Ribble Valley Borough Council
Planning Section
Council Offices
Church Walk
Clitheroe
BB7 2RA

Planning Application No: 3/2023/0421

Proposal: Proposed alterations and extension to existing dwelling including single storey rear/side extension, raising of roof pitches to rear, new chimney, fenestration changes to front and new parapet wall and rooflights to rear.

Location: Fairfield Farm, Longsight Road, Clayton-le-Dale BB2 7JA

original	project number	drawing number
Fairfield Farm	23.10	PL.01
Proposed Site Plan, Floor plans and Elevations		
scale	date	status
1 to 100 @ A1	may 2023	planning
		revision
		A

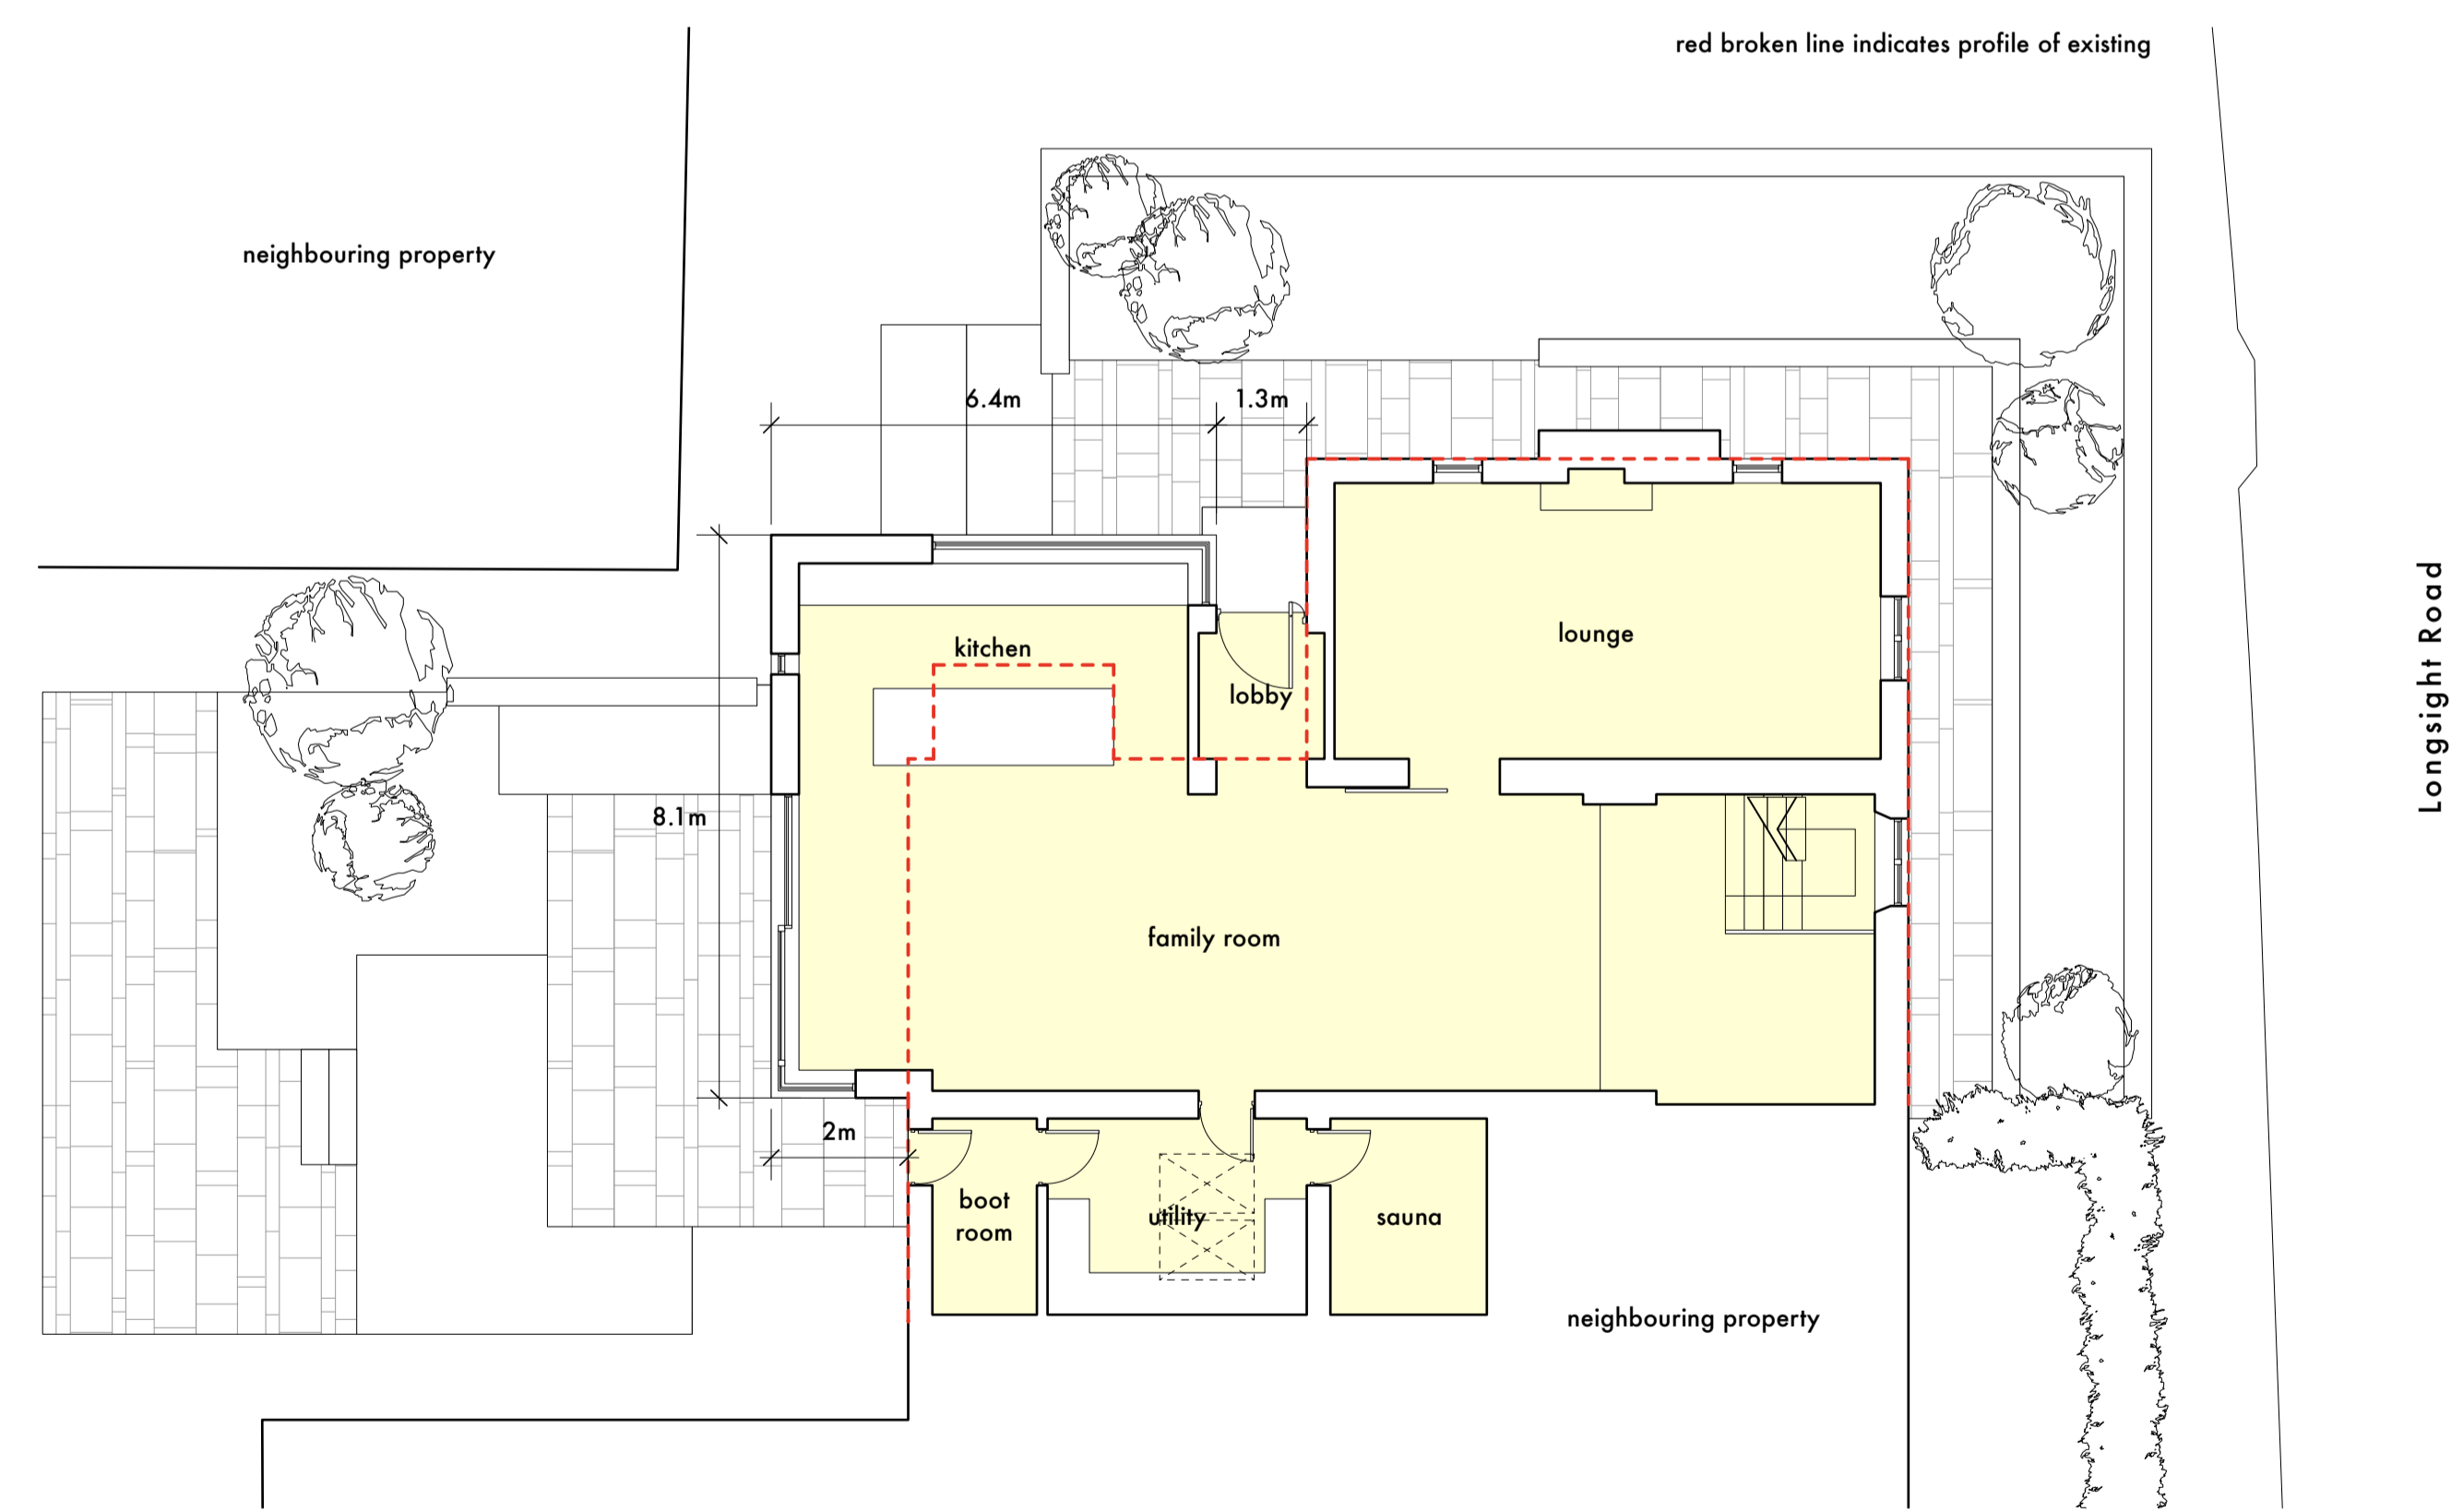
Although not shown on any of the submitted plans Public Footpath ref FP-03-13-001 (Clayton-le-Dale) passes through the site immediately adjacent to the existing dwelling on its Eastern boundary in a North-West/South-East orientation. This is shown on the extract from the county council's Public Rights of Way records (Figure 1). Historic images from Google Streetview also show the existence of a Public Footpath finger post in the grass verge in front of Fairfield Farm.

The proposed side extension would obstruct the recorded route of the above Public Right of Way, which the highway authority cannot support.

Public Rights of Way must not be obstructed during the proposed development. It is the landowner's responsibility to ensure that the necessary procedures are followed for the legal diversion of the Public Right of Way. The granting of planning permission does not constitute the diversion of a Definitive Right of Way. A temporary closure of a Public Right of Way will only be granted where it is the intention to re-open the right of way upon expiration of the closure on the route recorded on the Definitive Map of Public Rights of Way.

The development must not commence until the necessary procedures are in place, either allowing the development to take place without affecting the right of way as recorded on the Definitive Map of Public Rights of Way and subsequent diversion orders and side roads orders. Or, if it is necessary to divert the above listed Public Right of Way, then the necessary Orders must be confirmed prior to construction to avoid enforcement action should the above Public Footpath become affected. There is no provision under the Town and Country Planning Act 1990 to allow a retrospective diversion of paths that are already affected by either partially completed or completed development.
